February 9, 2016

RE: Project 1000310, 15EPC-40071, 40072, 40073

The purpose of this letter is to explain how we have addressed the Environmental Planning Commission's (EPC) conditions of approval for Project #1000310, Case Number 15EPC-40071, 40072, and 40073, a Sector Development Plan Map Amendment, a Site Development Plan for Building Permit, and a Site Development Plan for Subdivision Amendment which were approved on November 13, 2015.

L1.30
LANDSCAPE PLAN

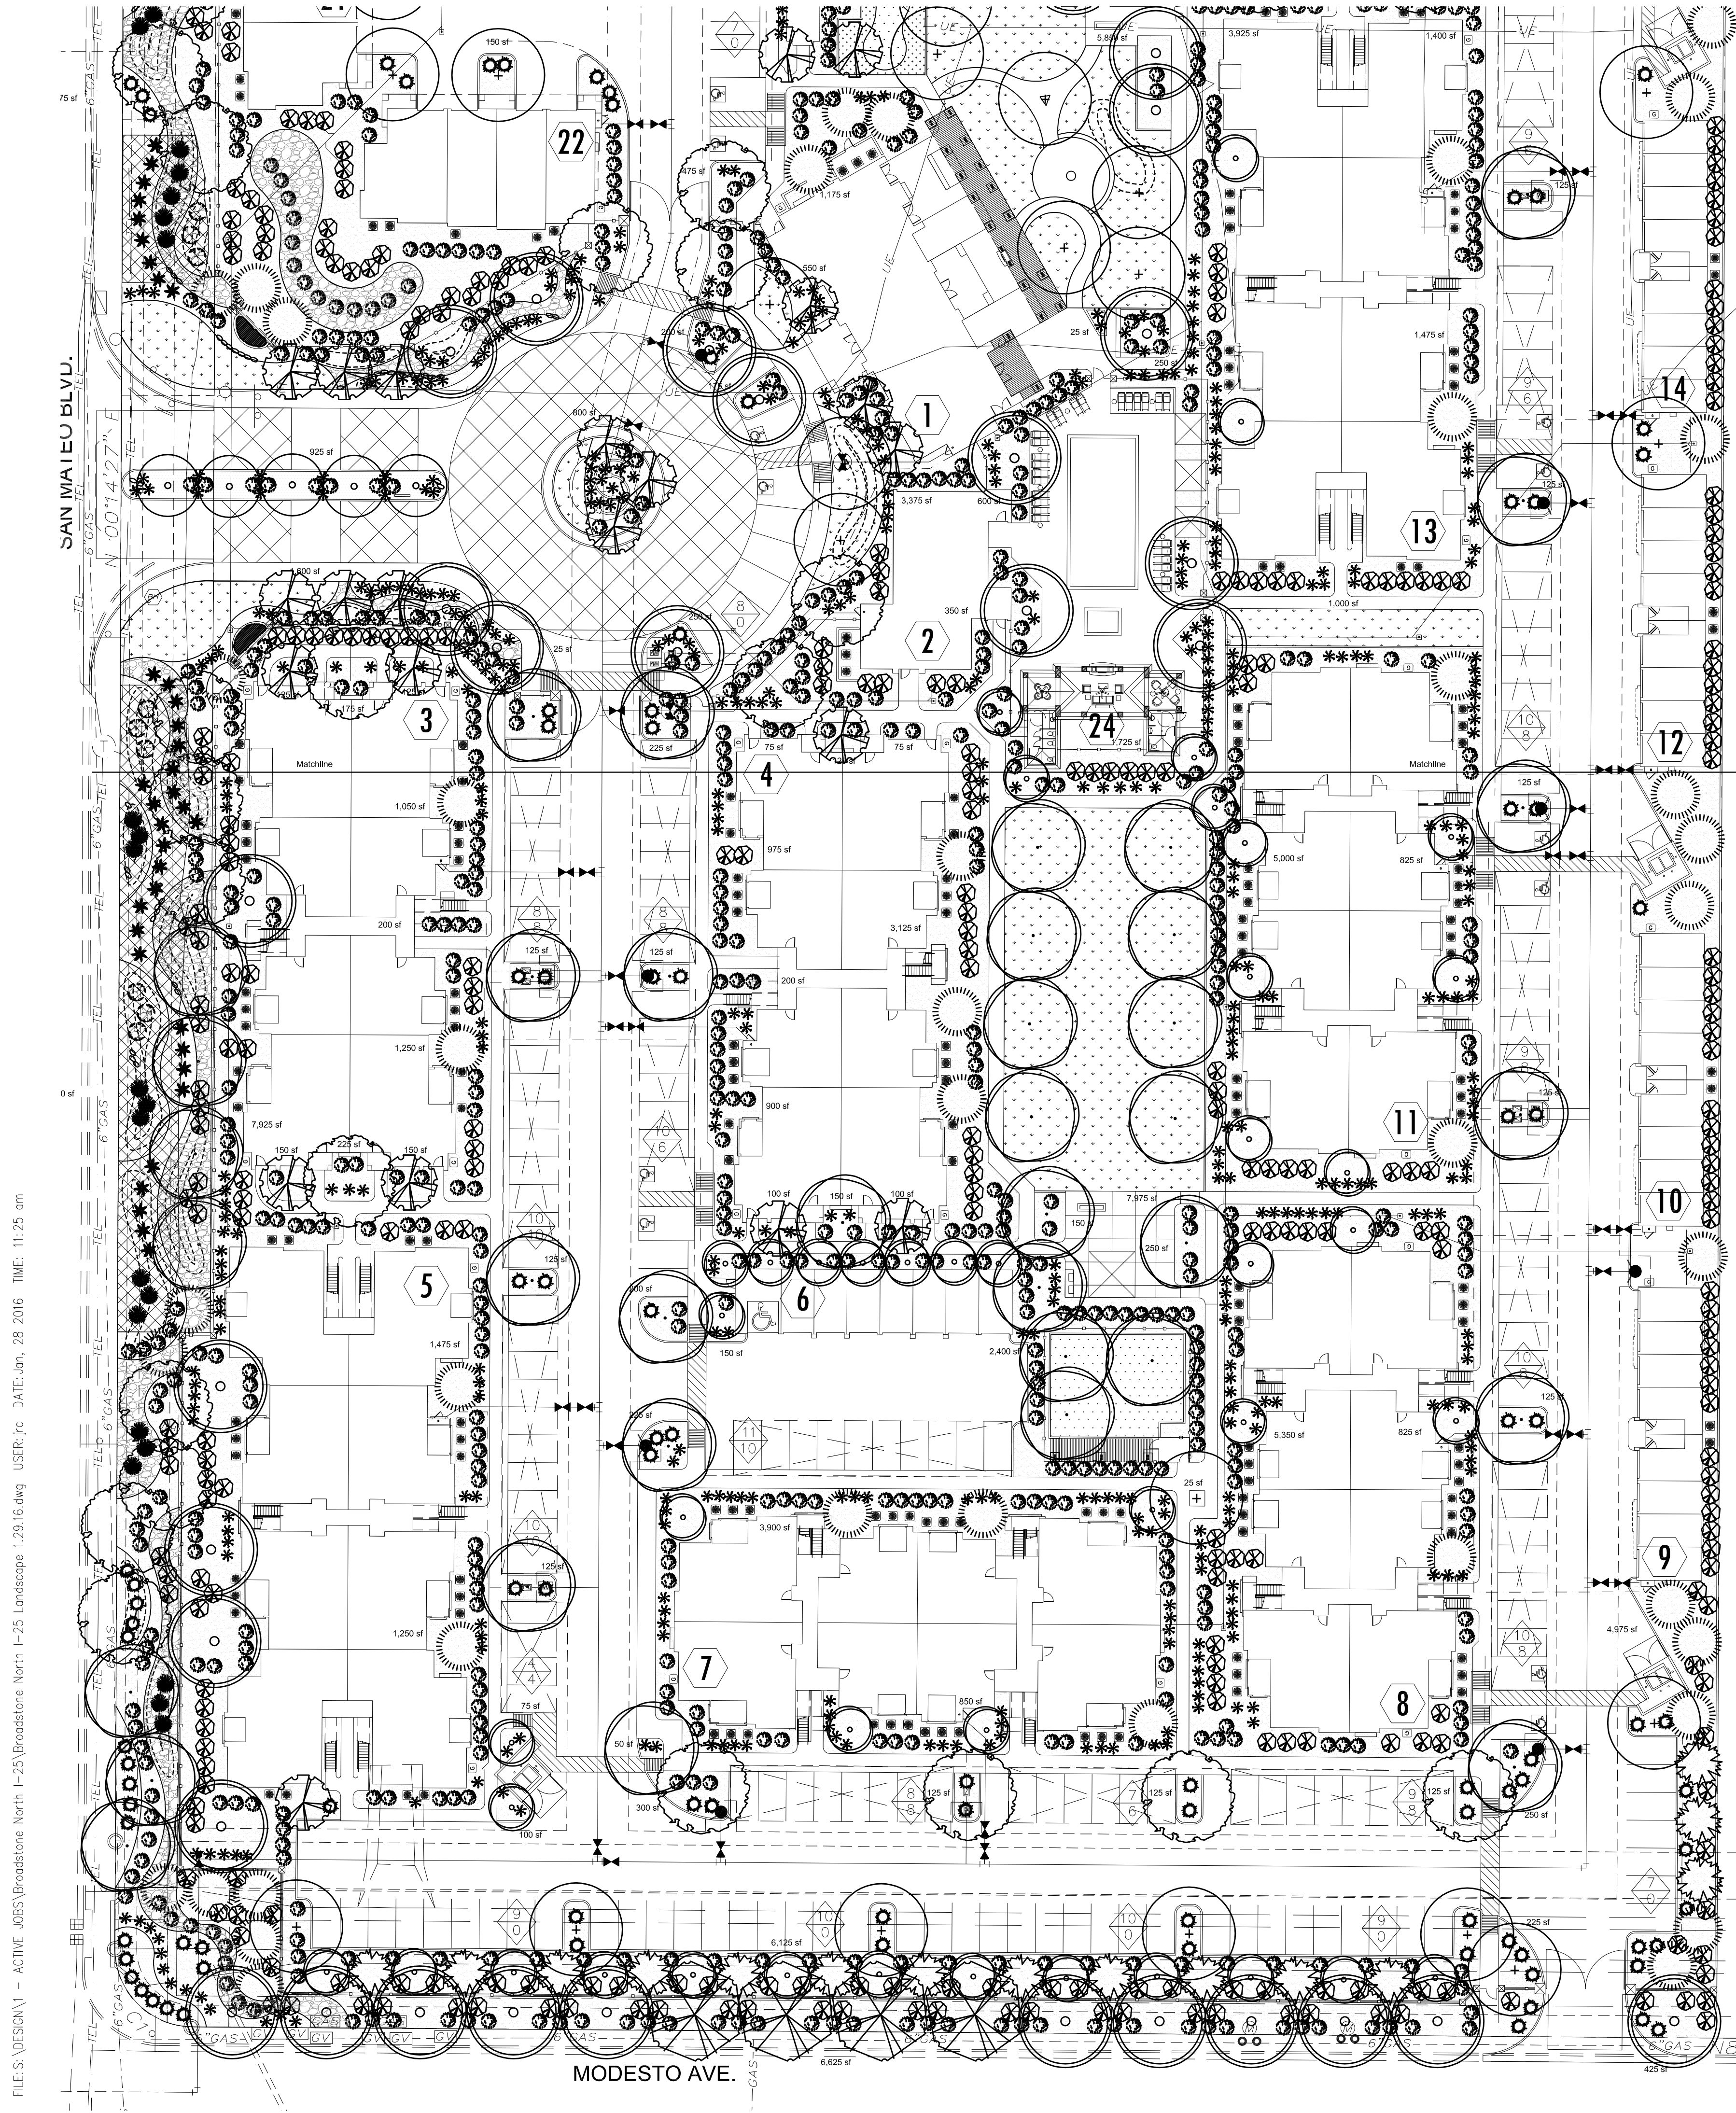
8. The Ocotillo shown on the Landscape Plan sheet L1.30 shall be replaced with a similar xeric plant, shrub, or tree.

We agree. We have replaced the Ocotillo with Dasylirion Sotol.
